Re: Environmental Noise Addendum Letter
30 Cleary Avenue, Ottawa
Gradient Wind File 23-234

Gradient Wind Engineering Inc. (Gradient Wind) was retained by Theia Partners to undertake an environmental noise assessment for the proposed development located at 30 Cleary Avenue in Ottawa, Ontario. The present addendum letter is supplemental to the January 2024 environmental noise report (ref. *Gradient Wind report #GW23-234 – Environmental Noise Assessment*, dated January 10, 2024), and addresses changes in the current architectural drawings as compared to the original architectural design.

Aspire Tower Elevations

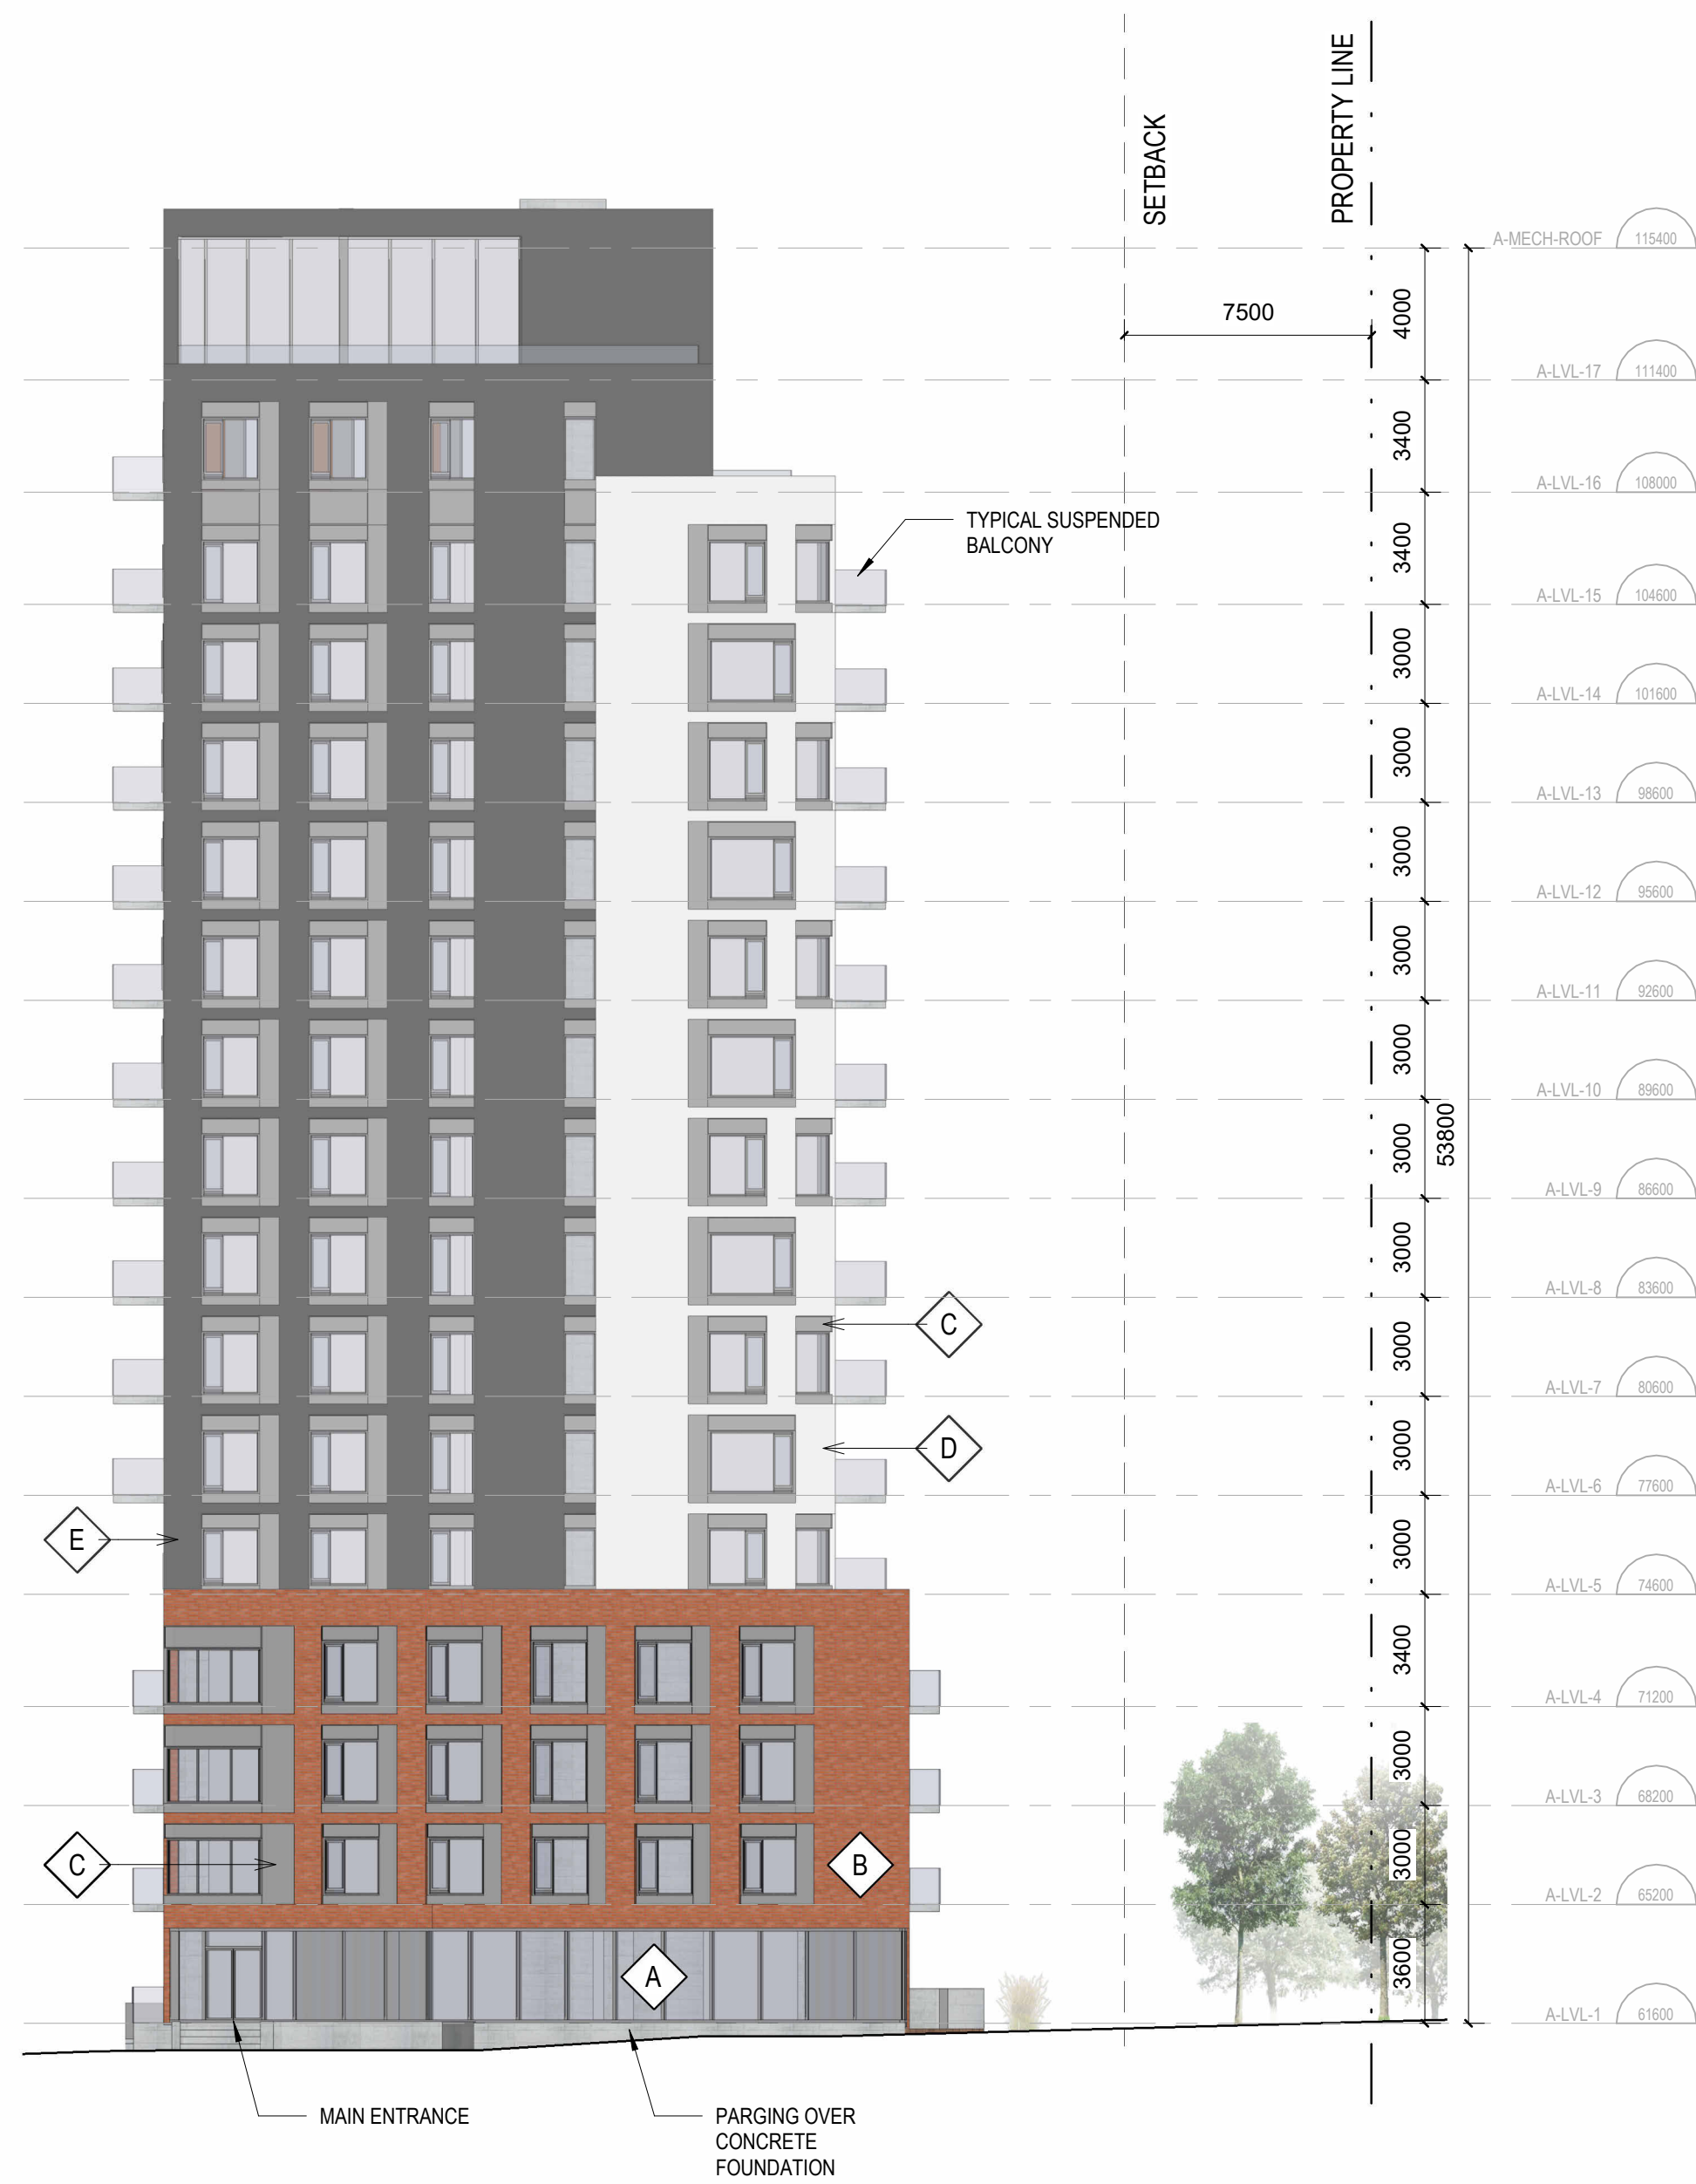
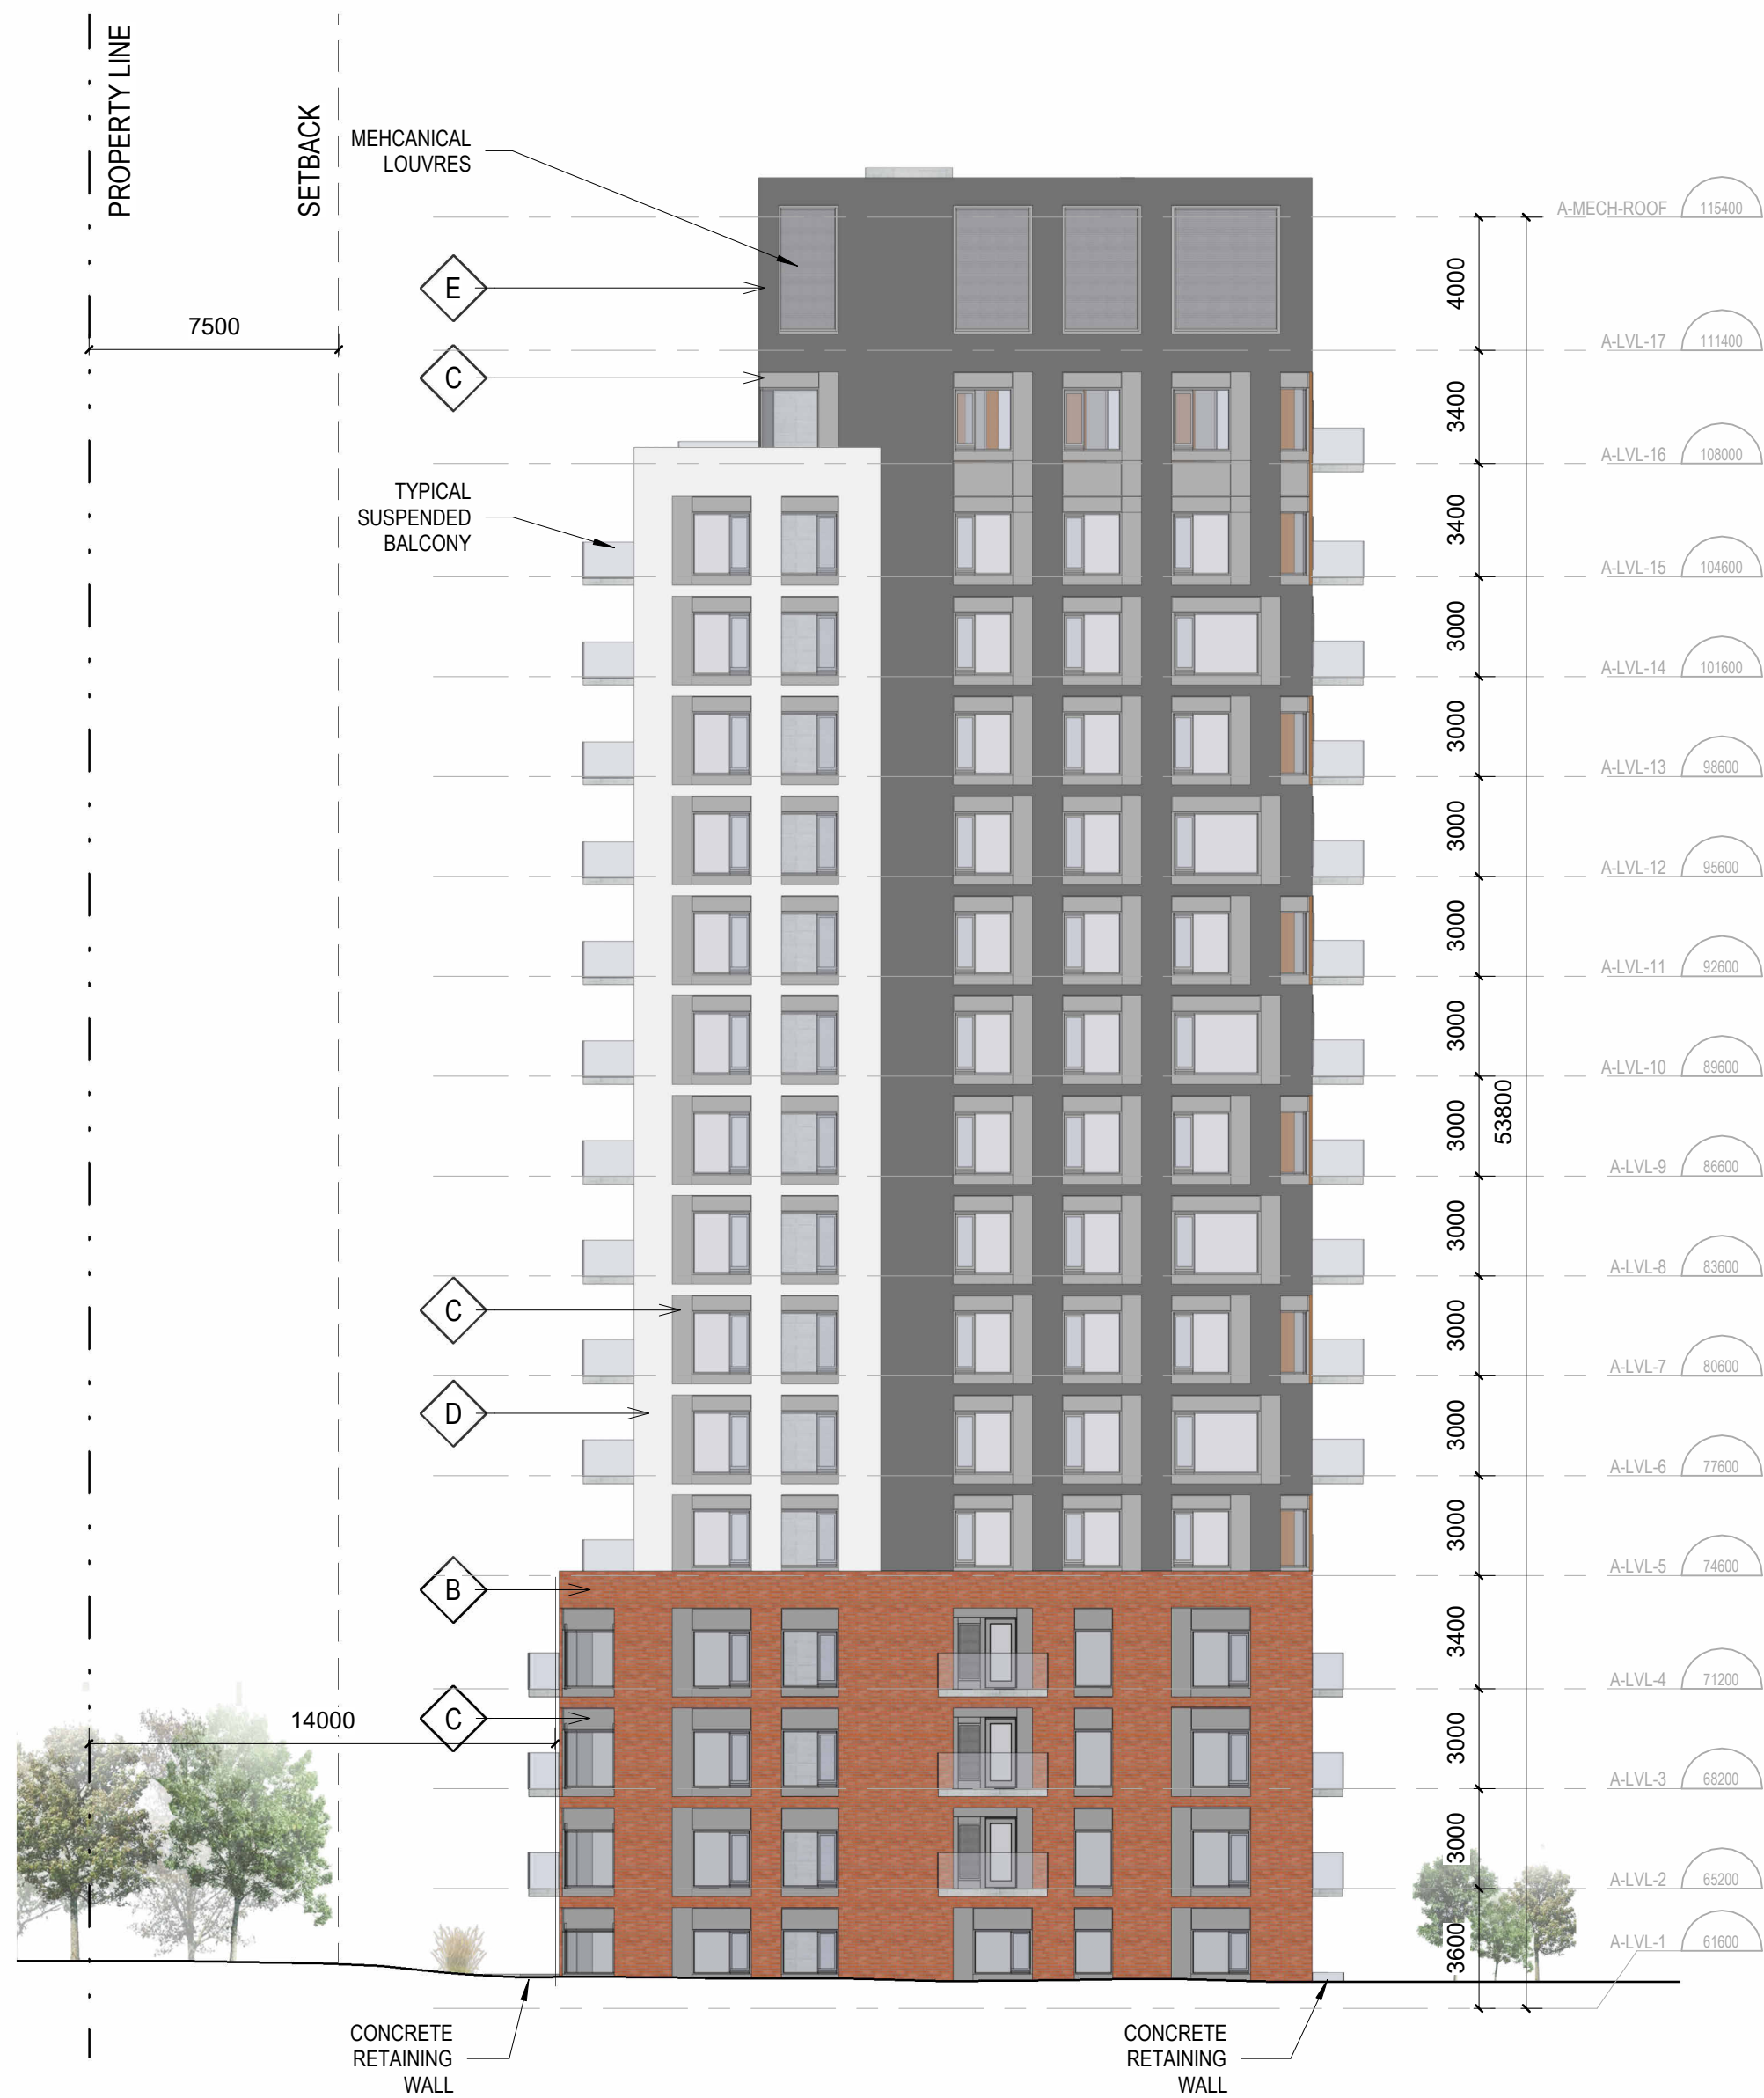
Upon review of the updated architectural drawings provided in February 2025¹, the revised building design retains a similar overall design to the tested configuration. Most notably, the building height has increased by 1.4 metres (m) and the stairwell at the southwest corner of Building B is now oriented east-west, revising the mechanical penthouse (MPH) planform. Additionally, the southwest corner of the common amenity terrace serving Building B at the MPH Level has been removed, decreasing the area from approximately 727 square metres (m²) to approximately 225 m². Furthermore, Building A now only includes setbacks along the full north and west elevations and from the south elevation at the southeast corner instead of all elevations at Level 5.

From an acoustics perspective, the drawings do not depict significant changes to the building design that would alter the noise impacts onto the development from transportation noise sources. As such, the recommendations and conclusions of the detailed January 2024 environmental noise assessment remain unchanged.
